Parking Equipment Referred: /18/01		
STANDARD BOUNDARY SURVEY		
885-89 ARCADIA STREET		PORTLAND, MAINE
MADE FOR		
STAN GRISKIVICH		
COUSINS ISLAND		YARMOUTH, MAINE
JOB# 200092	DATE: 12/27/00	SCALE: 1"=20'
BOOK# 404	Titcomb Associates 133 Grey Road Falmouth, Maine 04105	
DISC#		
FILE#

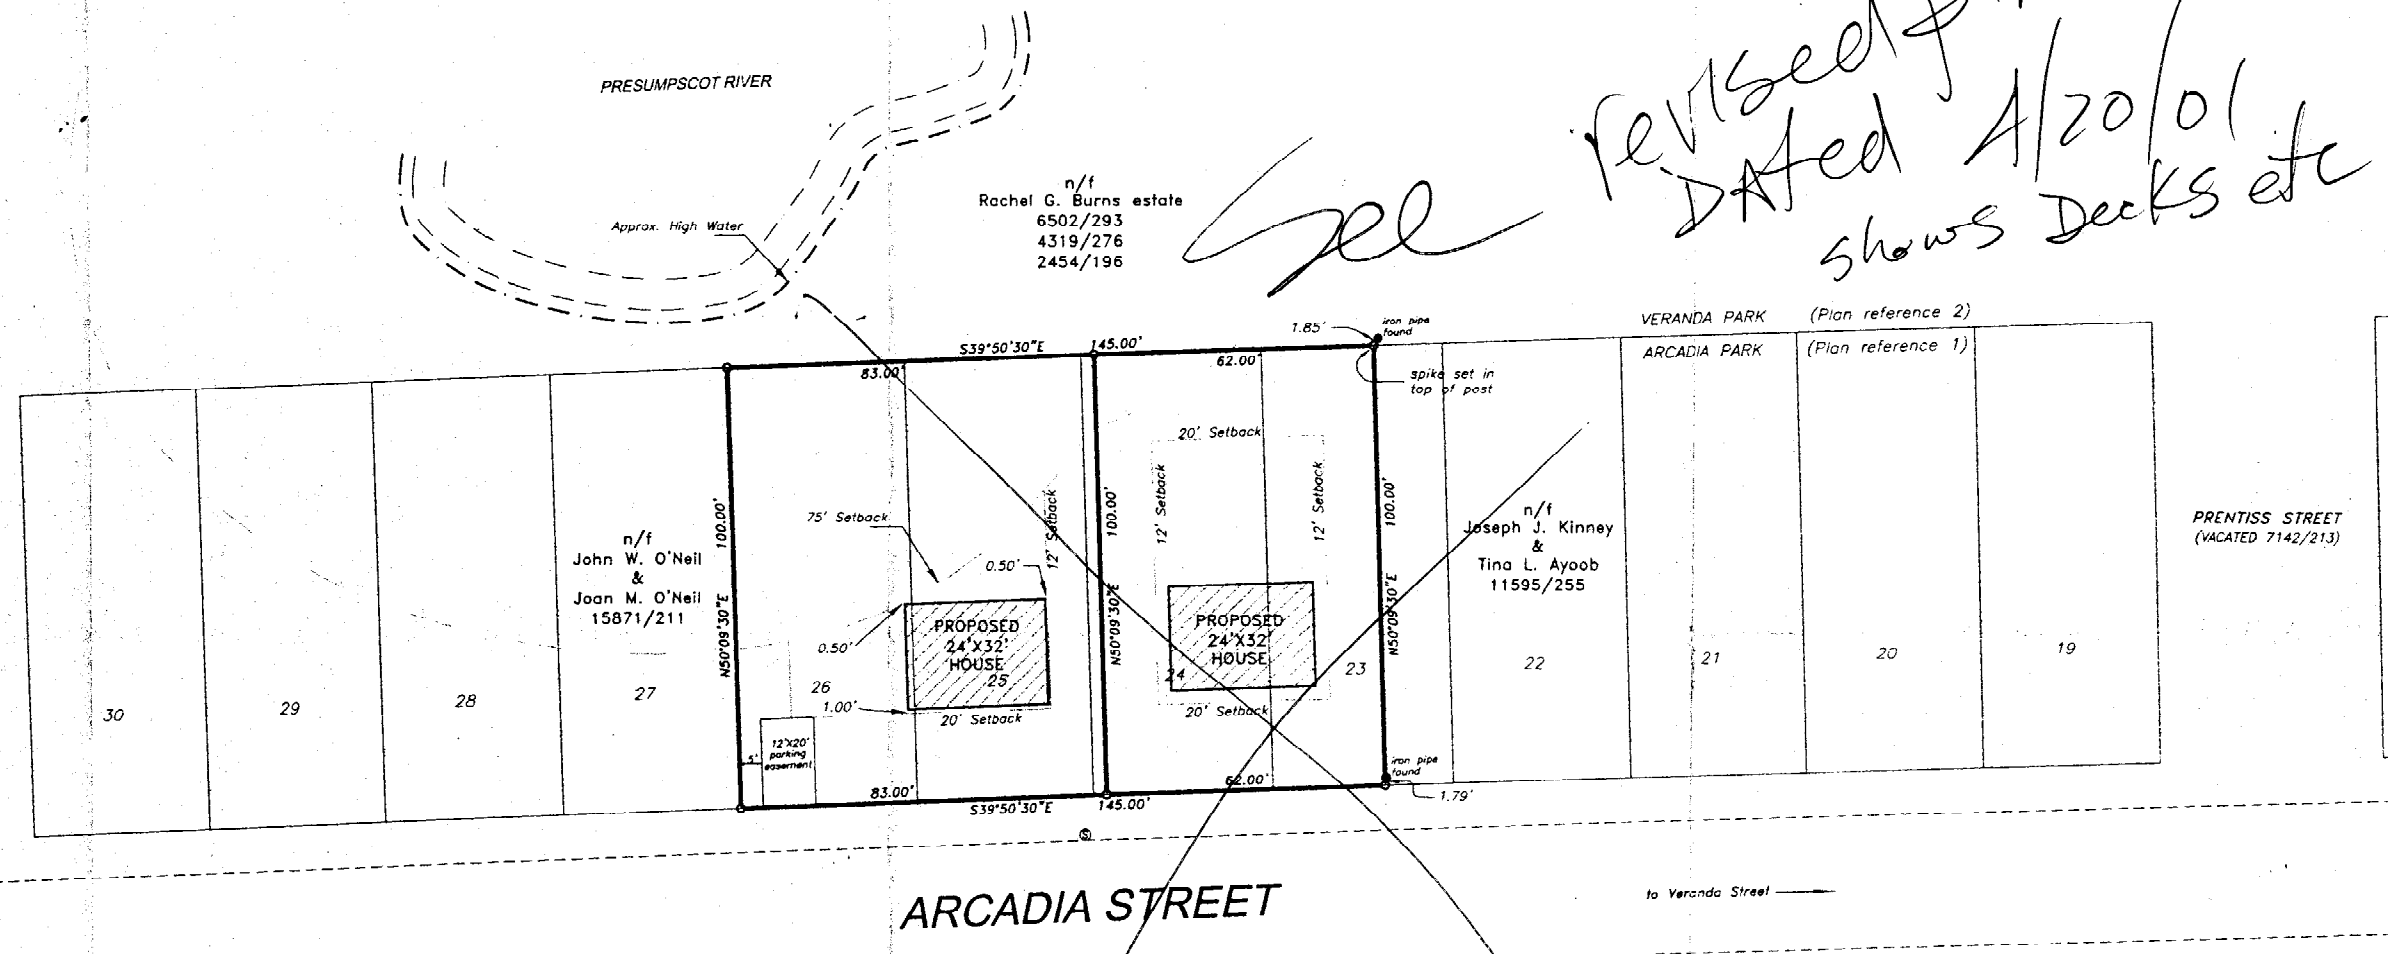
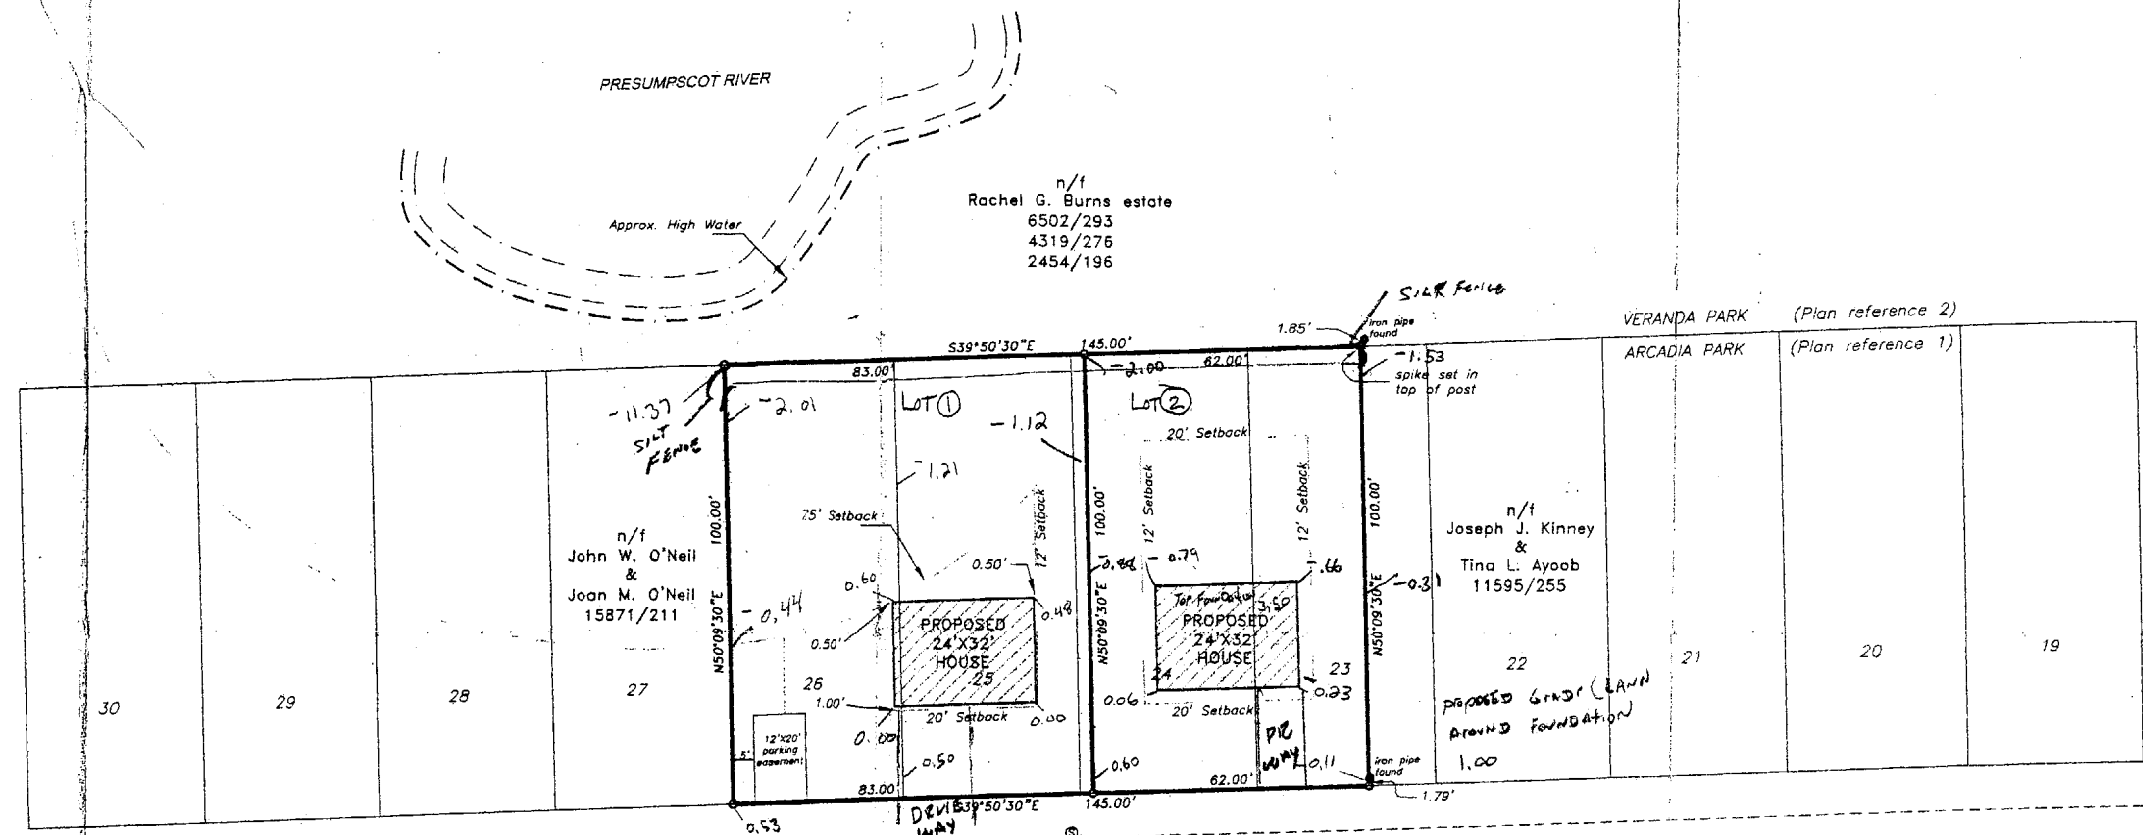
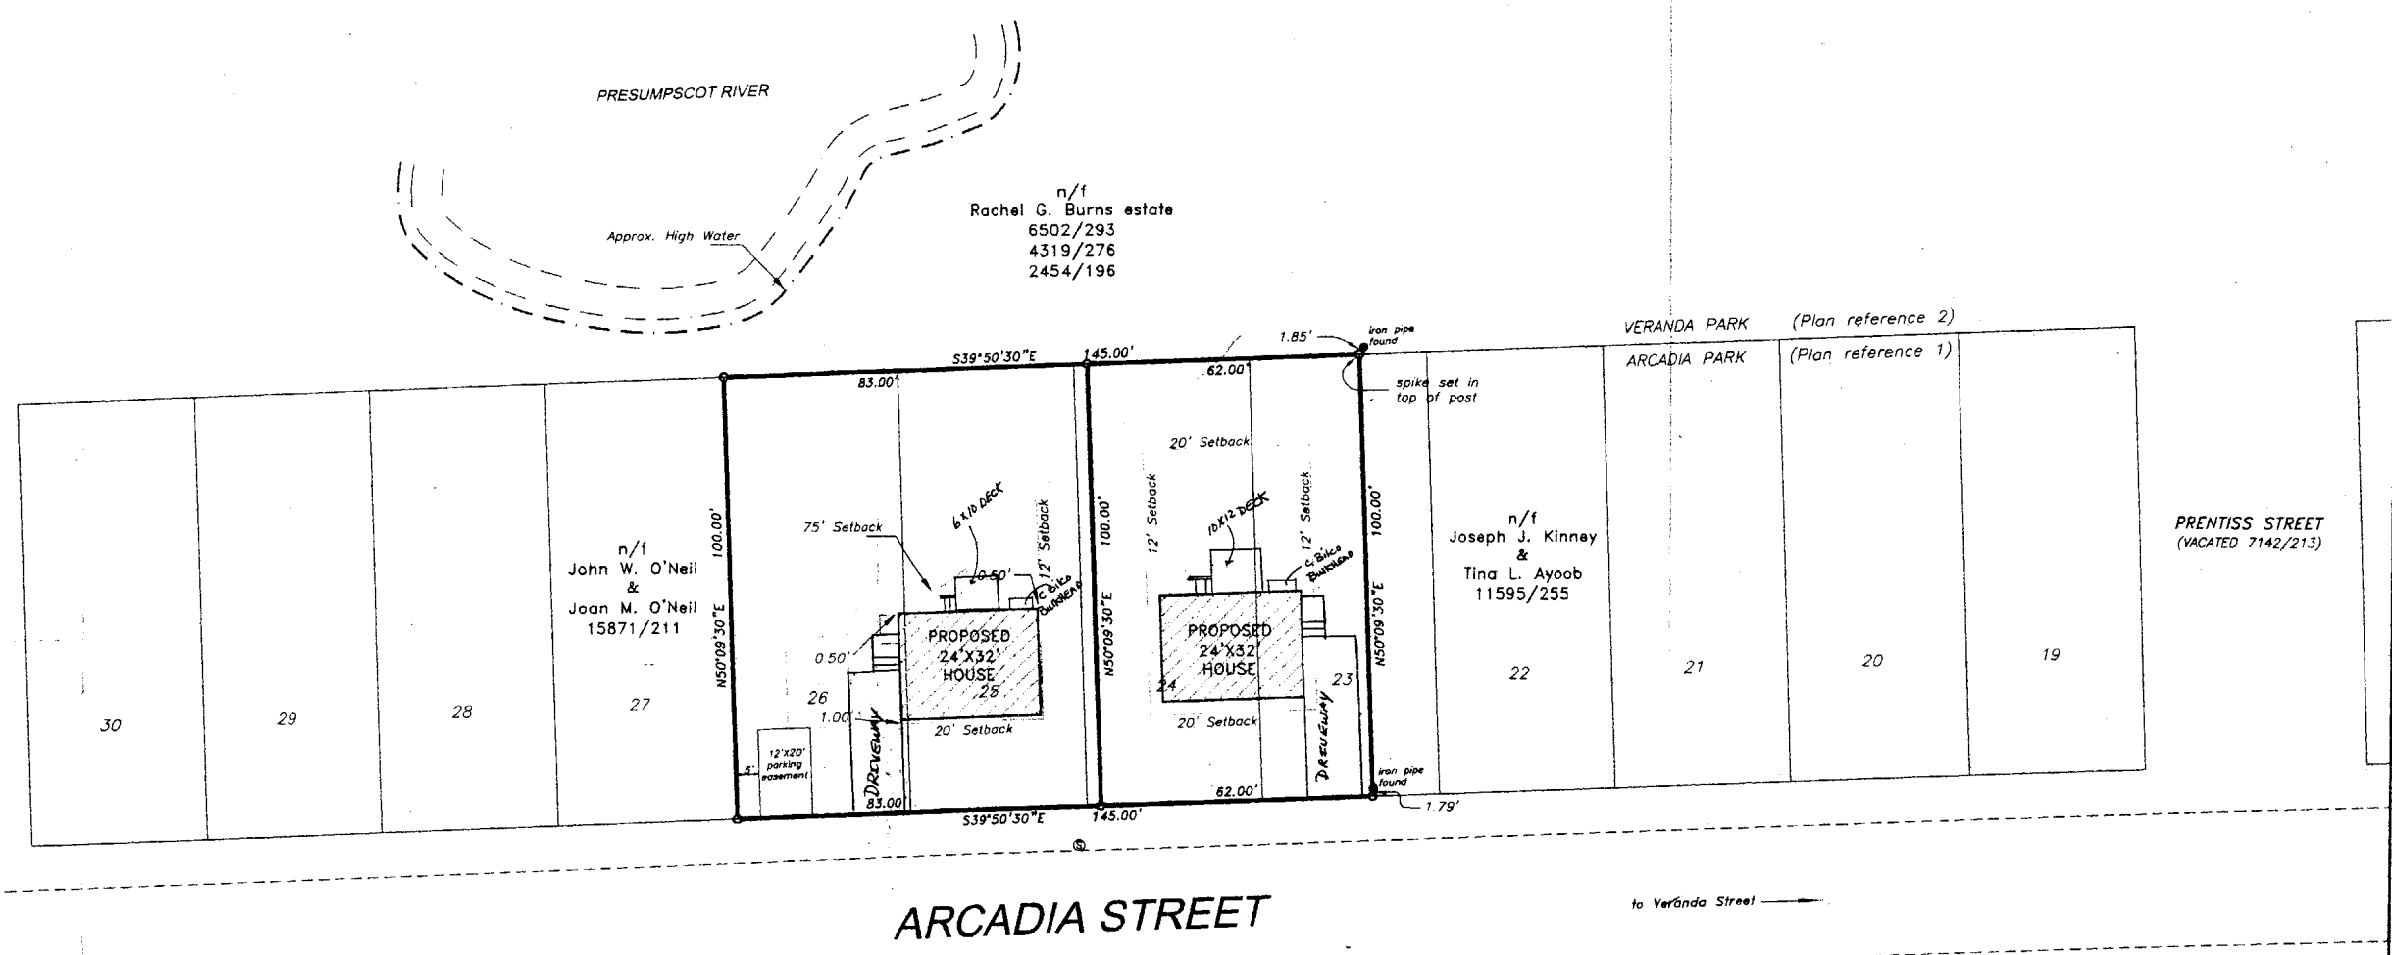
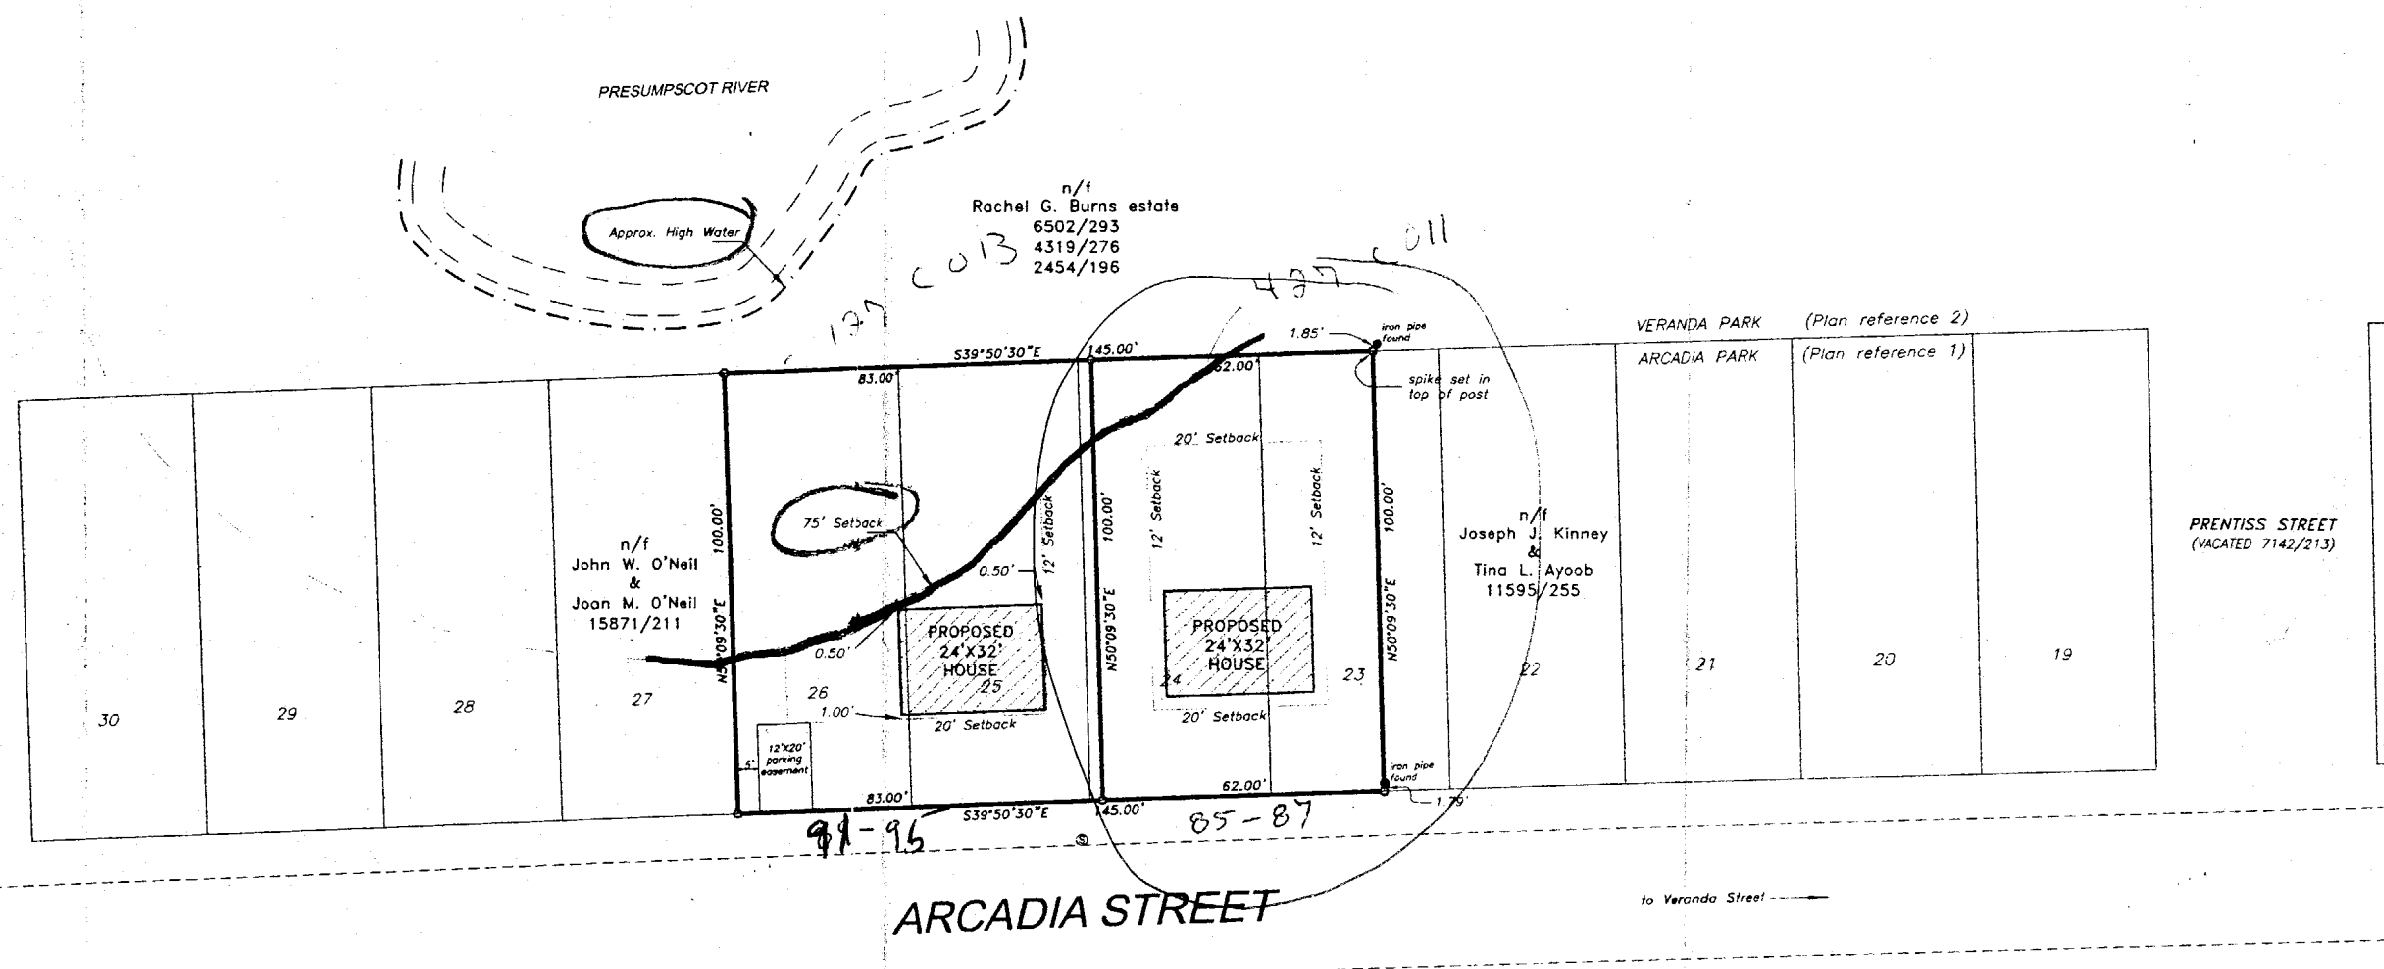
3/1/01 plot plan does not show deck or bulk head - Does not show parking for 2 cars - Does not show grade elevations or fill height elevation - left a voice mail, S

4/20/01 received revised plans, however the side set backs are wrong - left a page number and a message with wife at home - S

4/17/01 slw mullen explained what was needed, as stated above, will get it to us.

FRONT ELEVATION

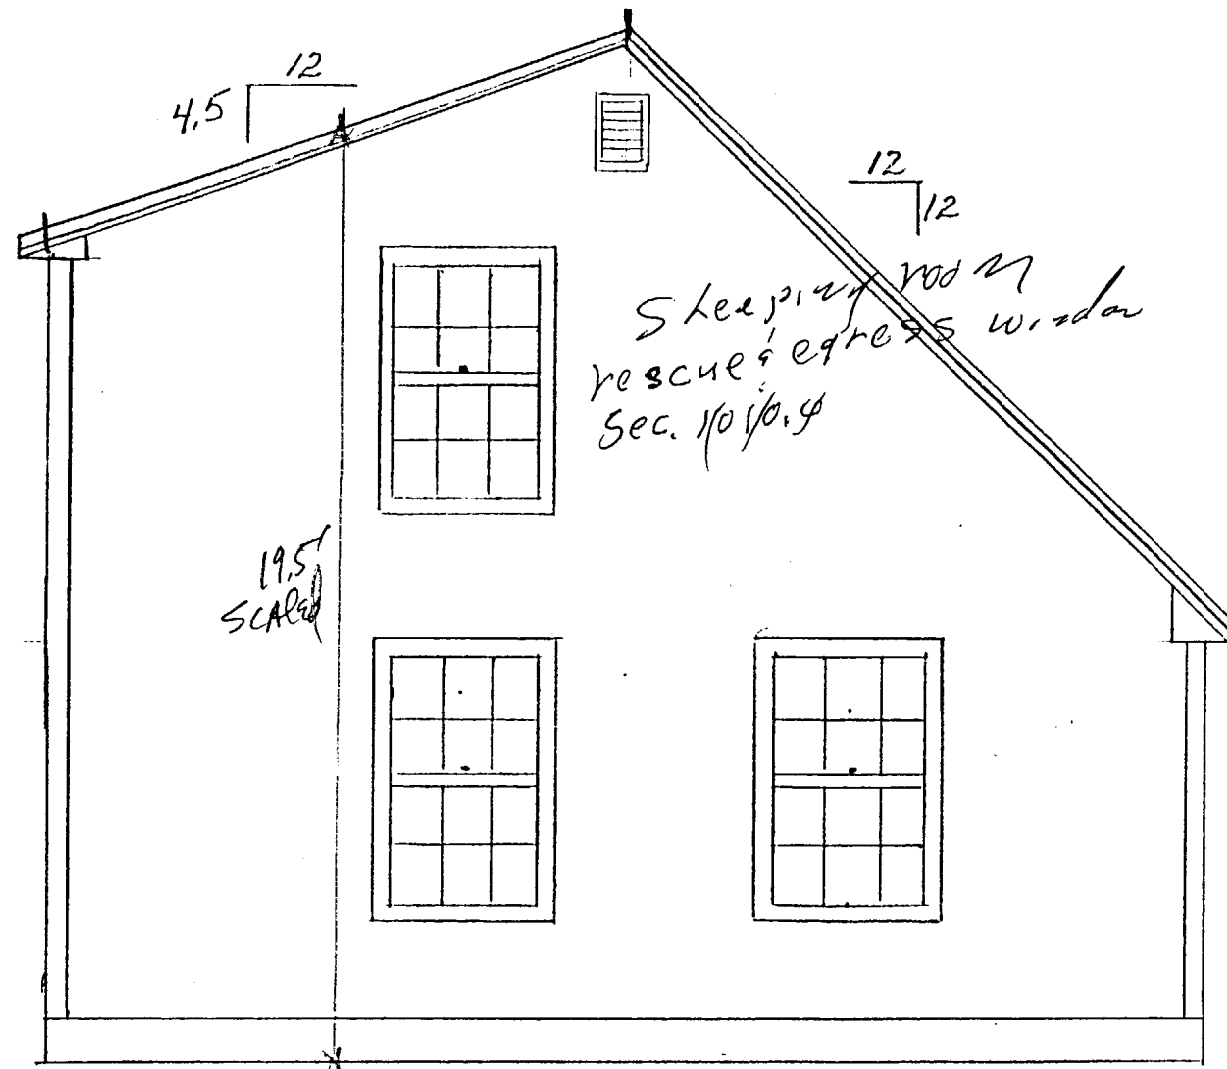
8-3-01 Final - need returns on handrails - switch plate covers - guards on front stairs - guardrails need to be 36" on rear ext stairs - need risers on bsmt stairs - TM & DC

8-7-01 - No guardrails on front stairs and grade not raised to 15 1/2" (TM)

8-6-01 - Everything completed except guardrails on front stairs (TM)

8-7-01 Raised grade on front - OK for GO (TM)
